RE: Case Reference: 320916, 320095 and 320094

Applicant: Coolpowra Flexgen Limited

Development: BESS, GAS Plant and GIS Substation

I wish to lodge a formal statutory objection to the above-referenced Strategic Infrastructure Development application. As a local resident living on lands 200 metres from the proposed site, this development will directly, adversely, and irreversibly impact my property, residential amenity, and the local environment.

Client	COOLPOWRA FLEXGEN LIMITED		
Project	COOLPOWRA (GIS)		
Title	PROPOSED SITE SURFACE & FOUL WATER LAYOUT		
Stage	PLANNING

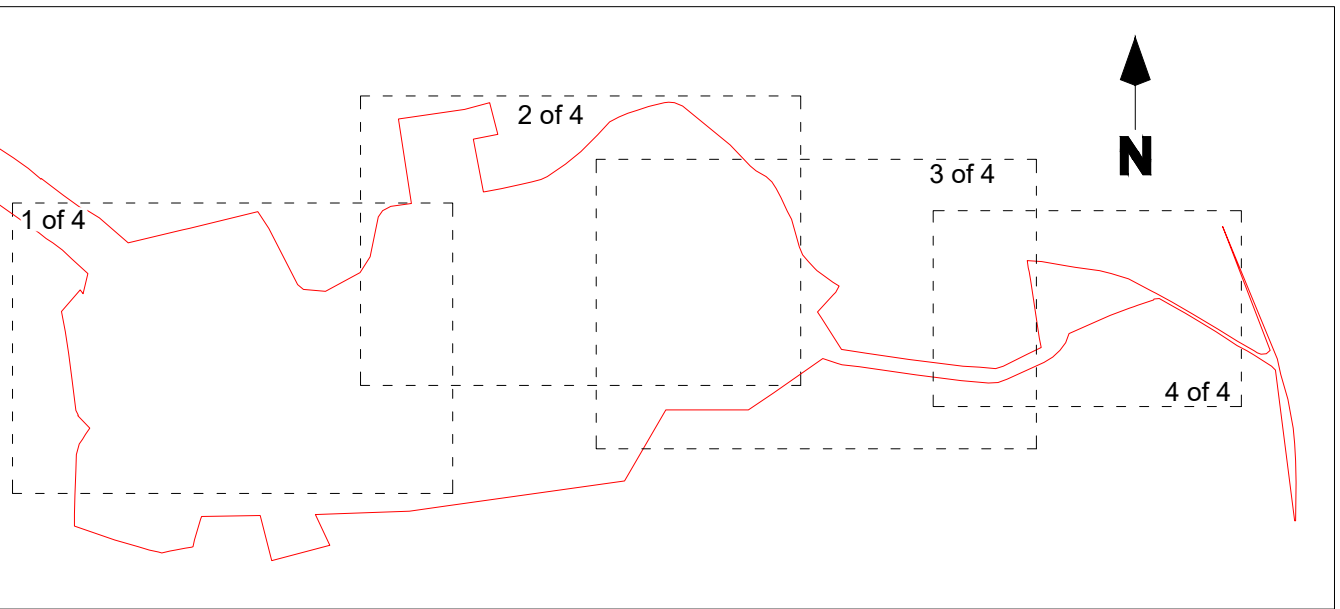
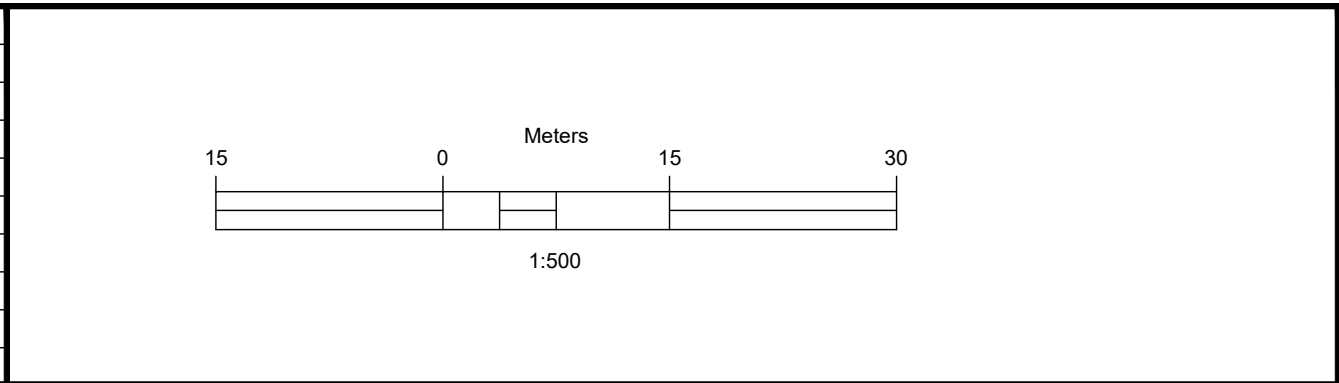
- **Redirection of Treananearla stream:** redirecting a small section does not avoid that fact that the majority of this stream will still travelling through the centre of this large scale site, in particular closely bordering 2 sides of the BESS. Should there be a fire at the battery facility (which is not uncommon in Ireland eg Claregalway) the stream will be directly hit.
